BE/104/14/NMA
cover letter

North Bersted – BRNRR – soft landscaping

We are pleased to enclose an application for non-material amendments to amend the soft landscaping scheme for the BRNRR which comprises the following material:

Drawing Number: 2115-PP-07 Revision: J

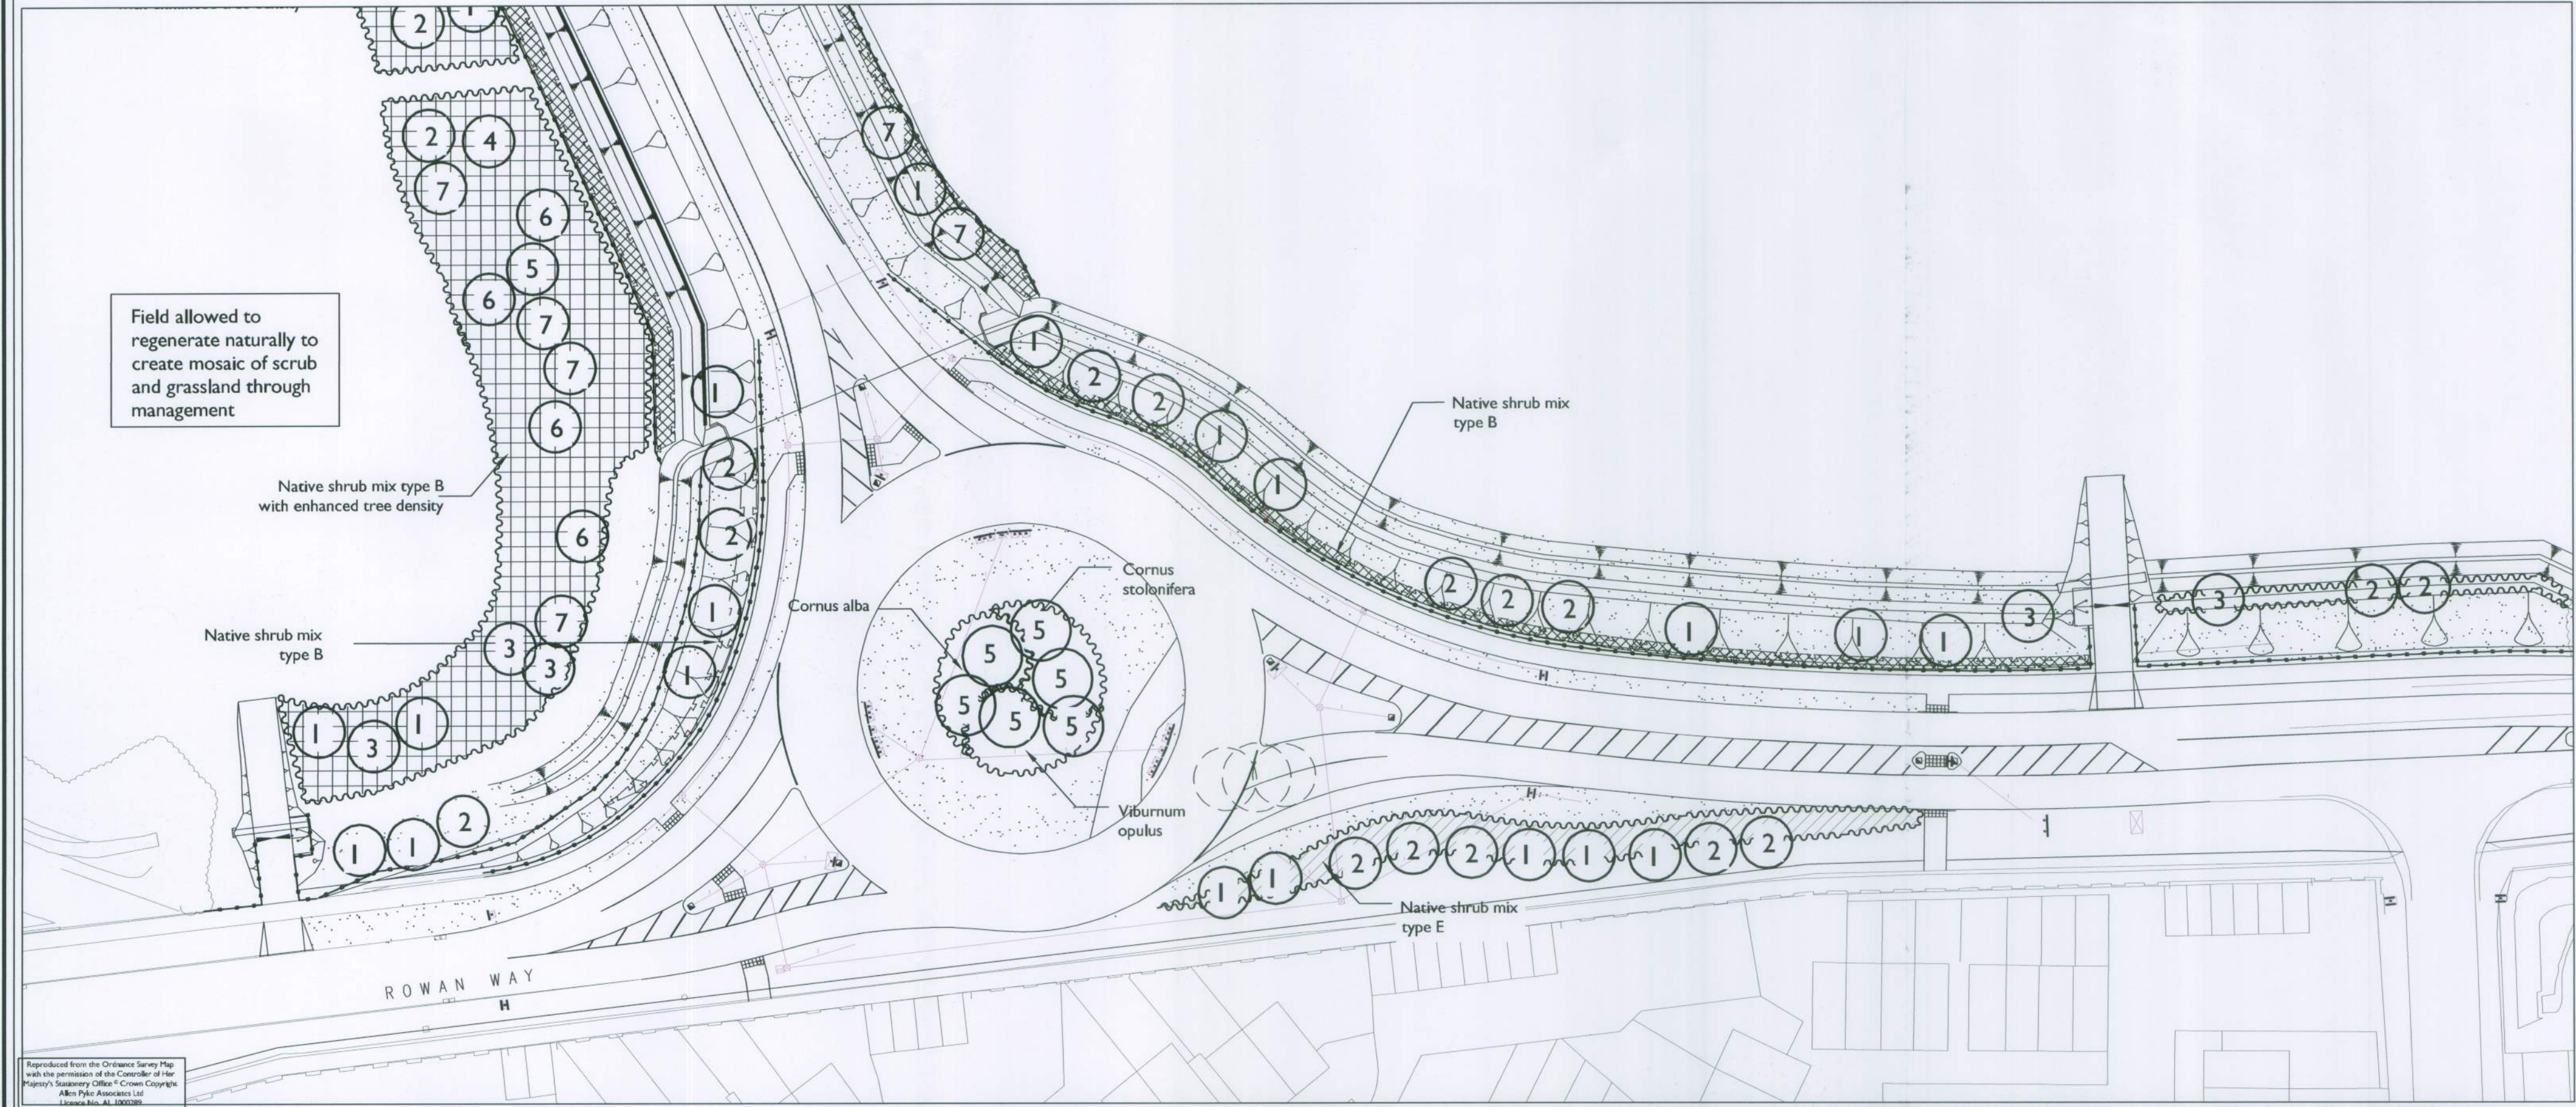
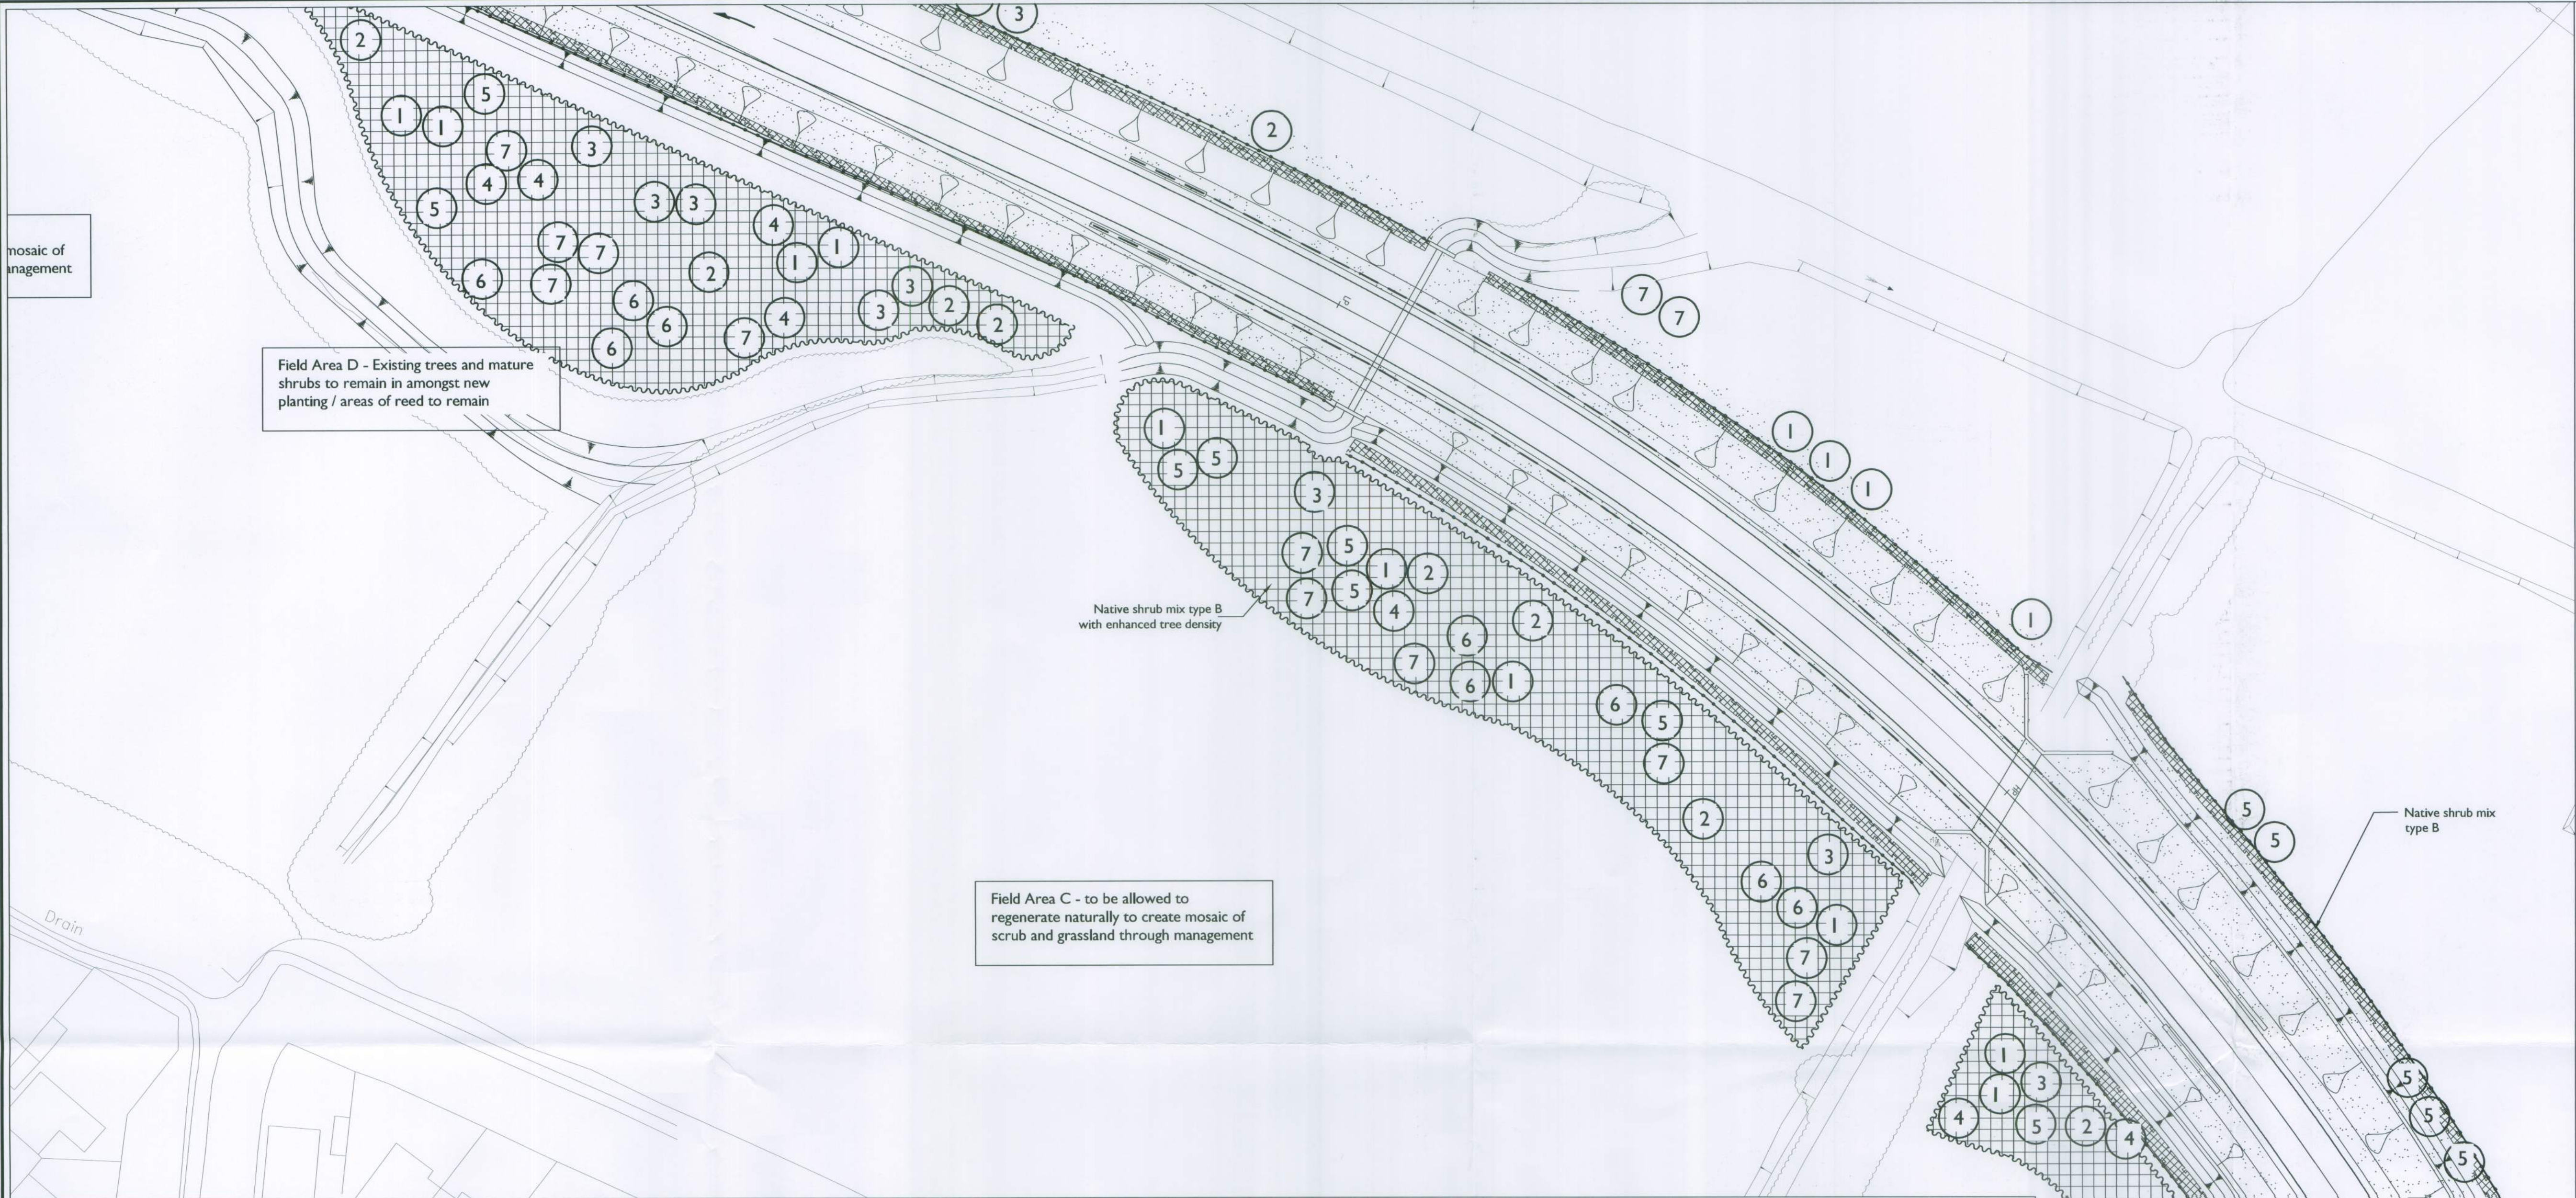
- Trees moved out of embankment and ditches
- Hedge moved from the top of the embankment and located at the bottom near the toe / fence
- Hedge moved to opposite side of toe drain and into verge.
- Field planting in the fields annotated to ensure existing trees and mature shrubs remain

Drawing Number: **2115-PP-03** Revision: **H**

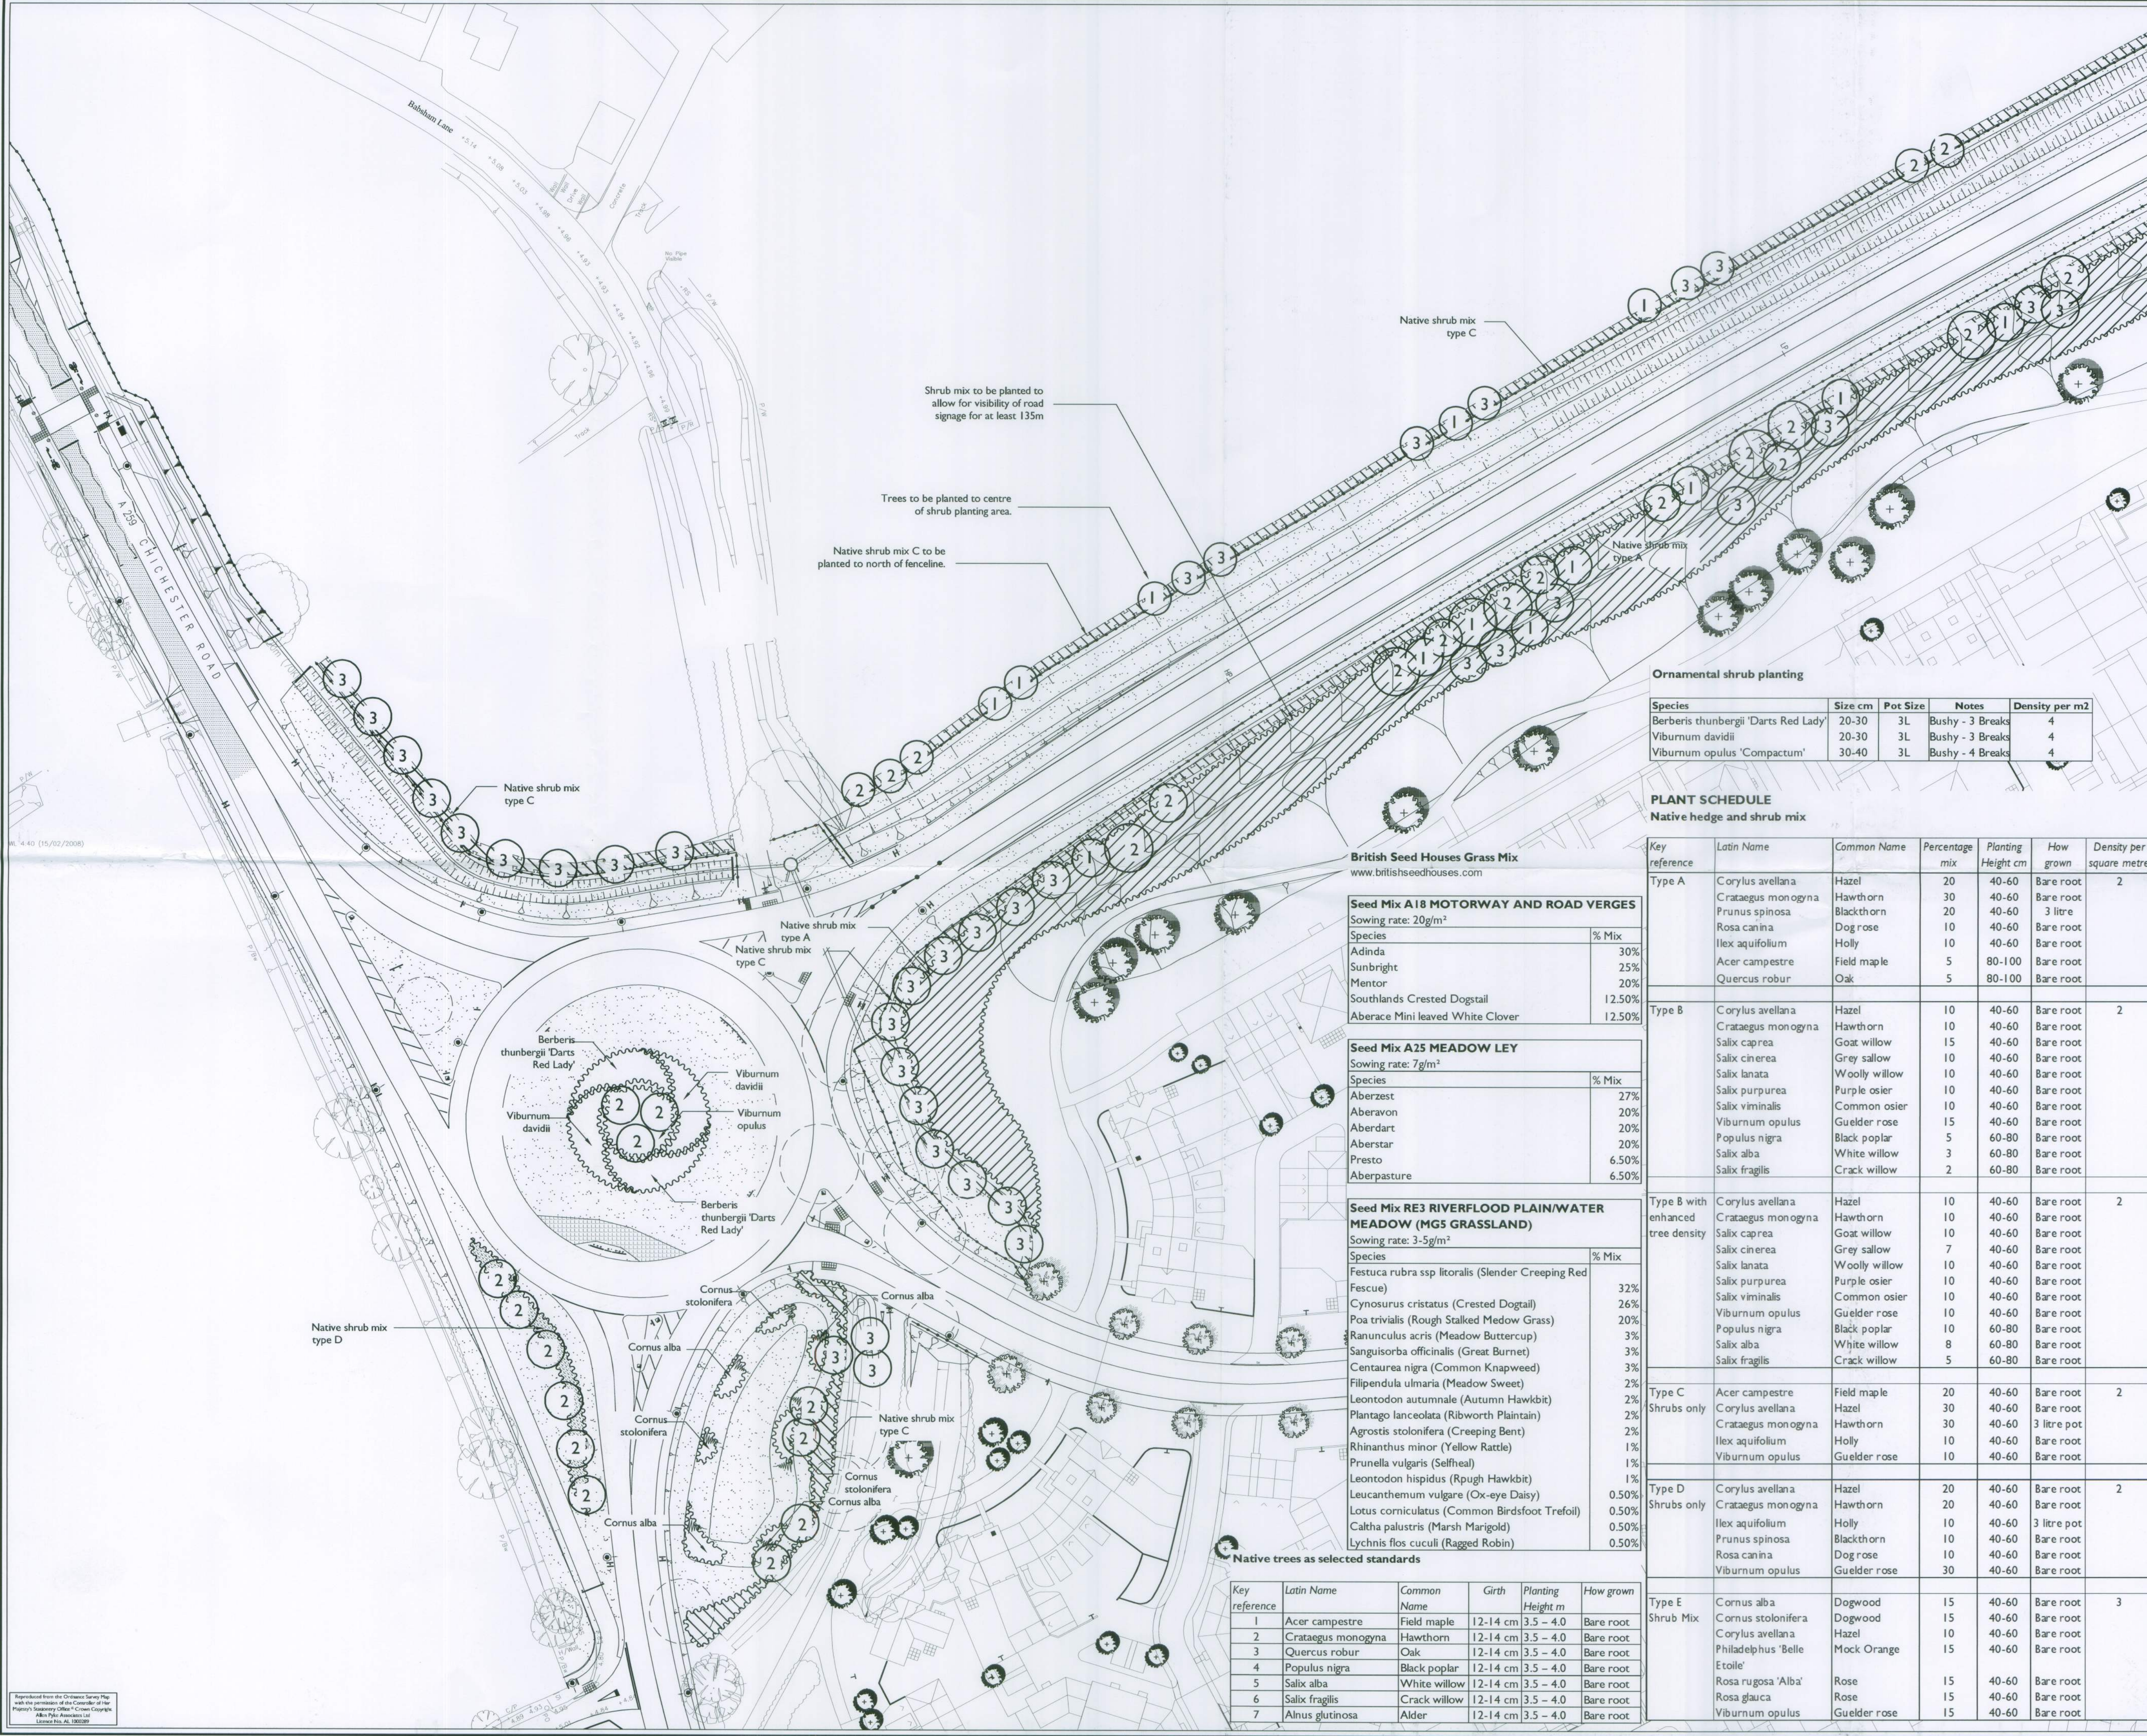
- Trees have been repositioned away from the sightline on the roundabout as the tree canopies will in time clash with the visibility splay on the approach to the roundabout
- Location of planting adjusted to reflect locations of road signs to ensure no obstruction
- Location of hedging outside northern boundary fence clarified
